Timberly, The Ridgeway, Beach Estate, Felpham

Planning Ref No: FP/263/18/PL

SIDE / SOUTH FACING ELEVATION SHOWING PROPOSED BRICK WALL

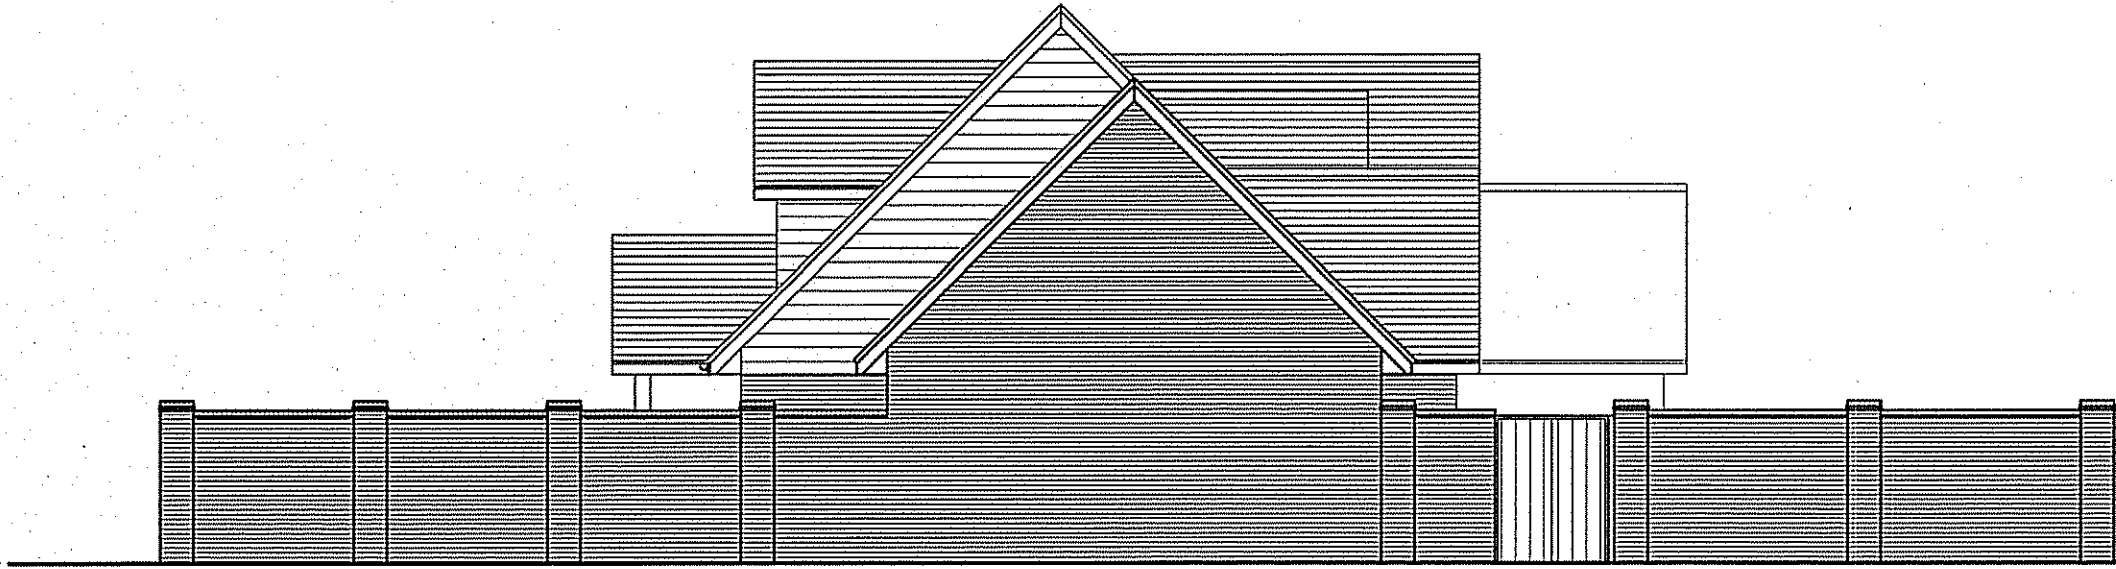
One assumes that it would have been preferred to maintain a privet hedge on the Minton Road boundary line, consistent with the adjacent allotments/ Minton Road boundary line and in keeping with the semi rural/ beach side character of the estate. Unfortunately the privet hedge is now beyond recovery and we fully understand that the new owners want to create a secure boundary, as has been proposed with the 6ft high brick wall with brink piers. May we suggest however that this is constructed with the character of other walls on the estate in mind, perhaps, as an example, incorporating some Sussex brick and flint features, with a view to softening the overall appearance?

PROPOSED
SITE PLAN

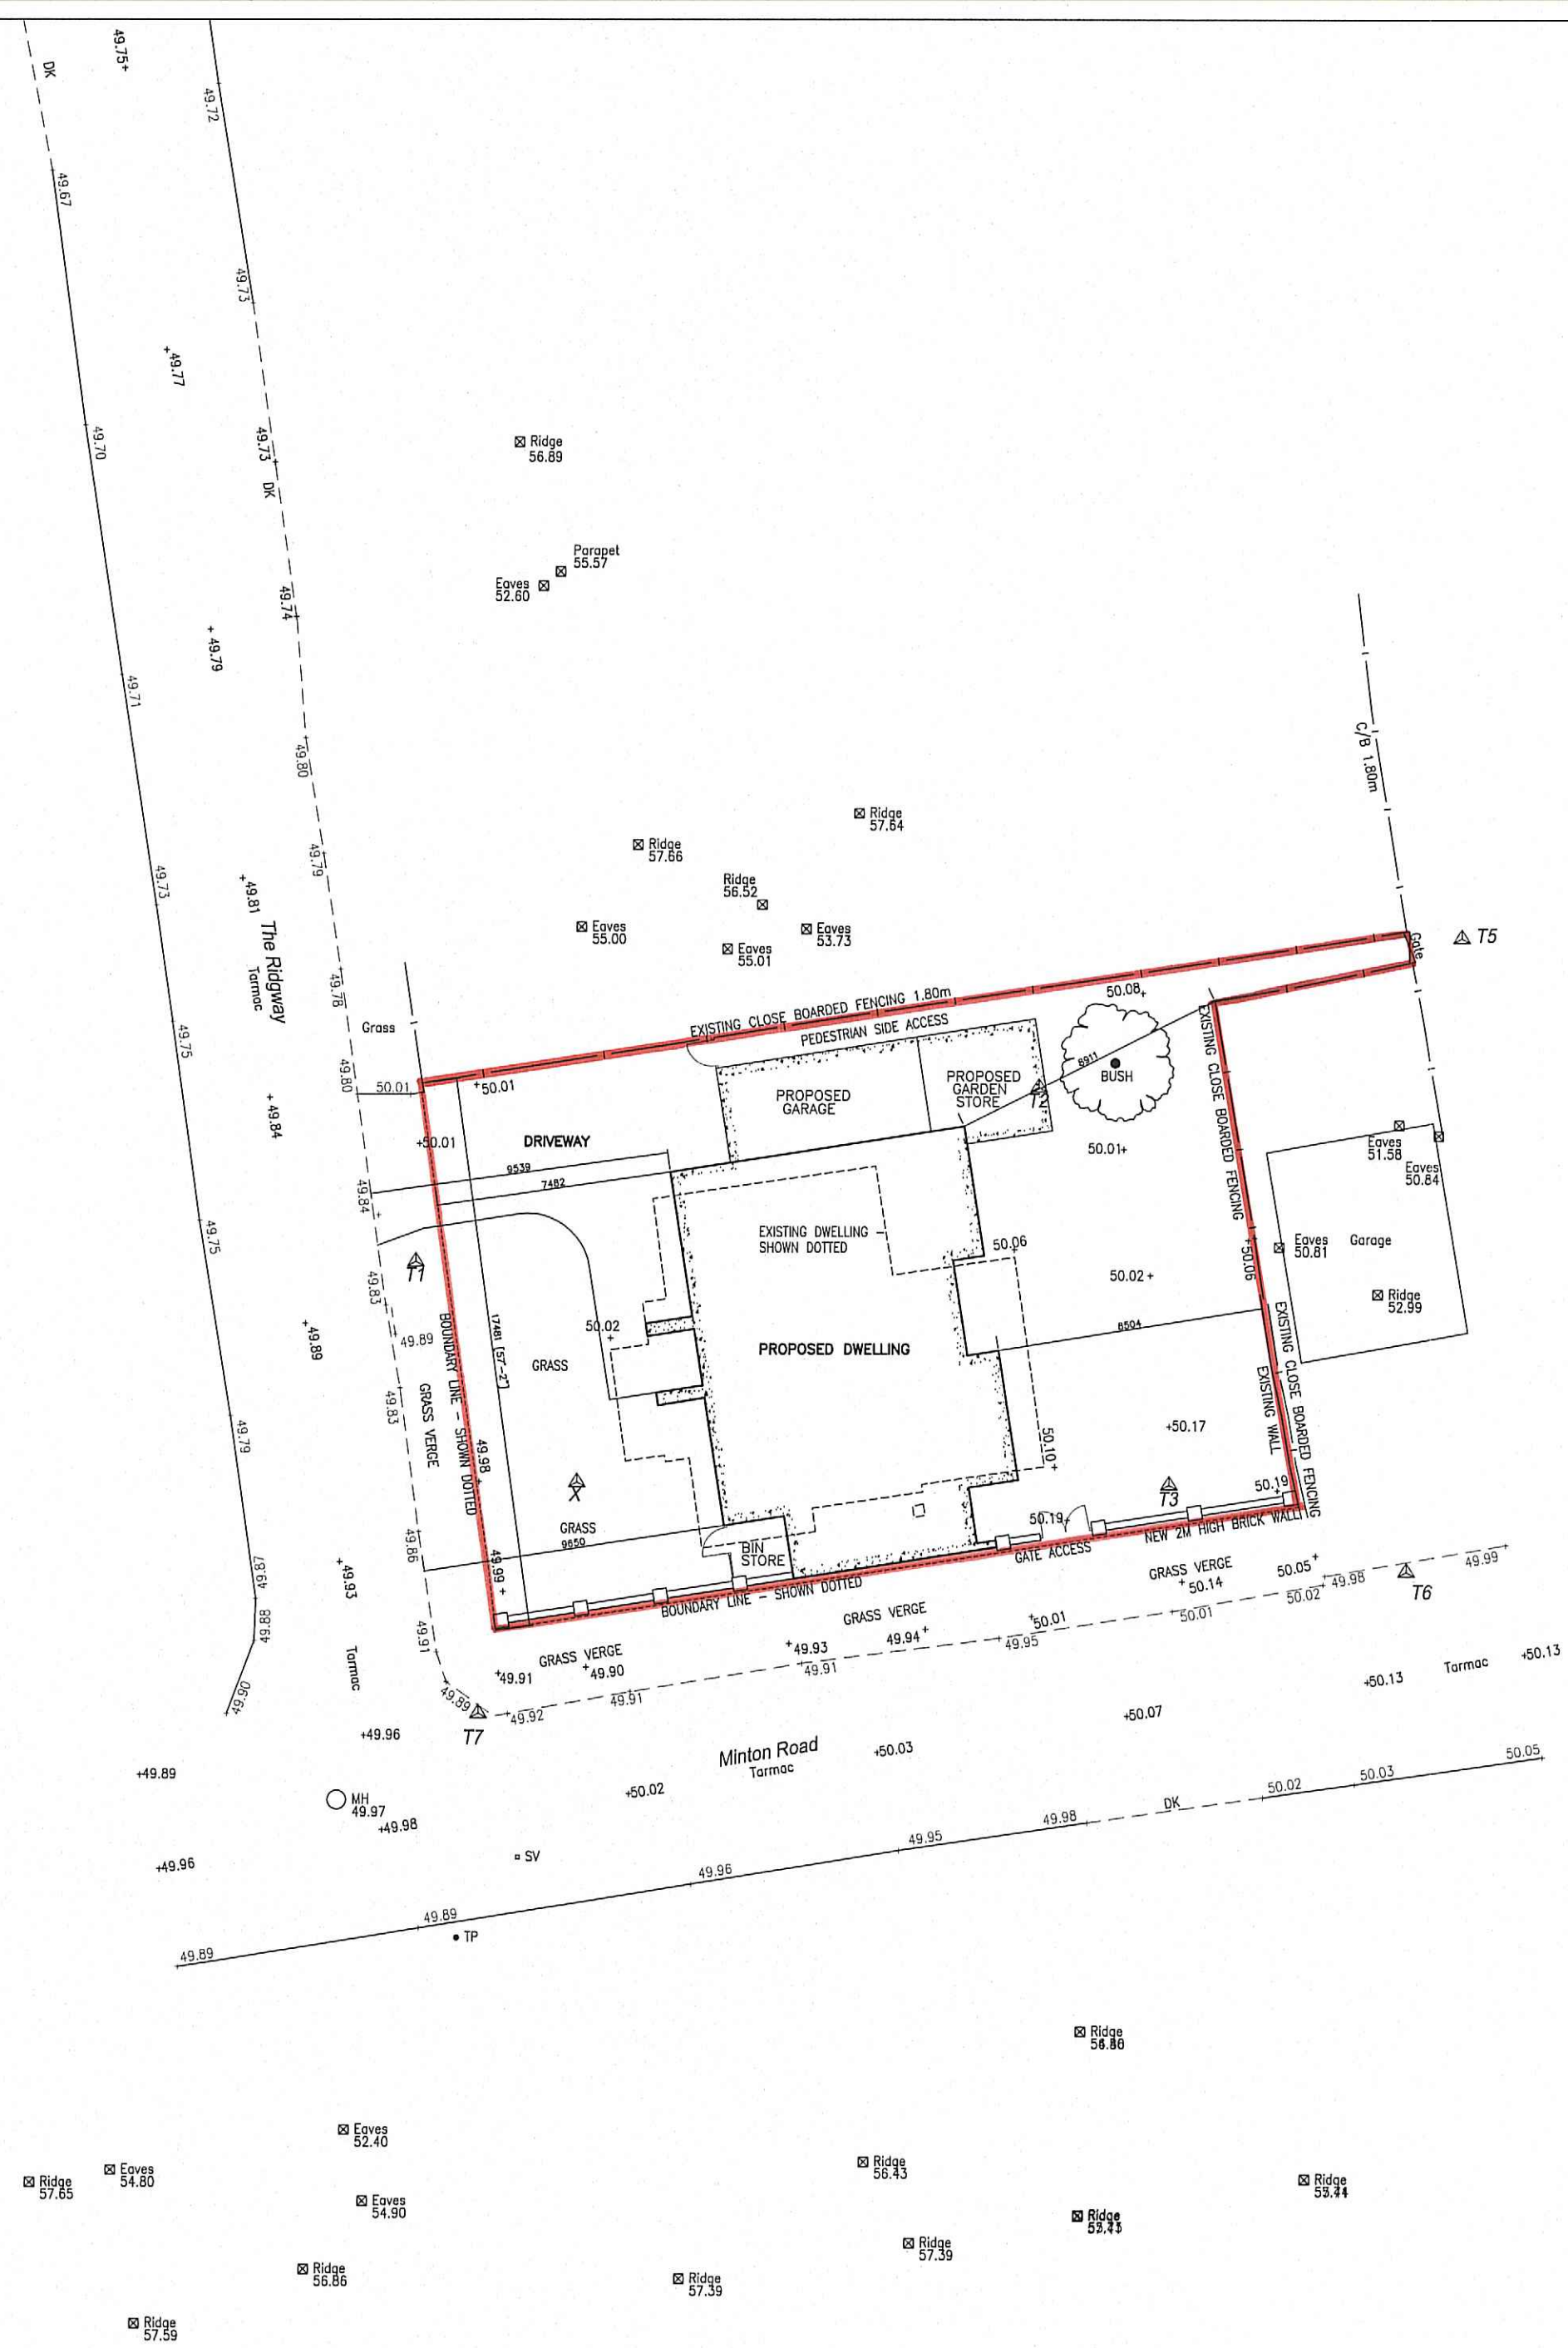
In accordance with the covenant within the conveyance document (17th Aug 1987 Clause 3) for the sale to us of the Timberly garage site, it was specifically agreed *"by the Vendor for herself and her successors in title"...(b)"not to construct or cause to be constructed any access point into Minton Road from the Retained Land"*.. ie the remaining Timberly site. We therefore wish to object to the creation of the new side gate access.

We see no reason to create a further access point and break up Timberly's long established Minton Road boundary line. In particular Minton Road already suffers on occasions from unauthorised parking along this boundary line which would potentially be encouraged (even on a temporary/ drop-off basis) if a new Minton Road rear access point to Timberly was created.

The proposed access point is directly opposite our own property's driveway, thereby creating a potential hazard for our own parking and access purposes when a vehicle is parked there. This would also be unsightly, particularly from our kitchen bay window seating area, from where we would much prefer to continue to enjoy our view of an uninterrupted Timberly boundary line, as was contracted to in the 1987 Conveyance.
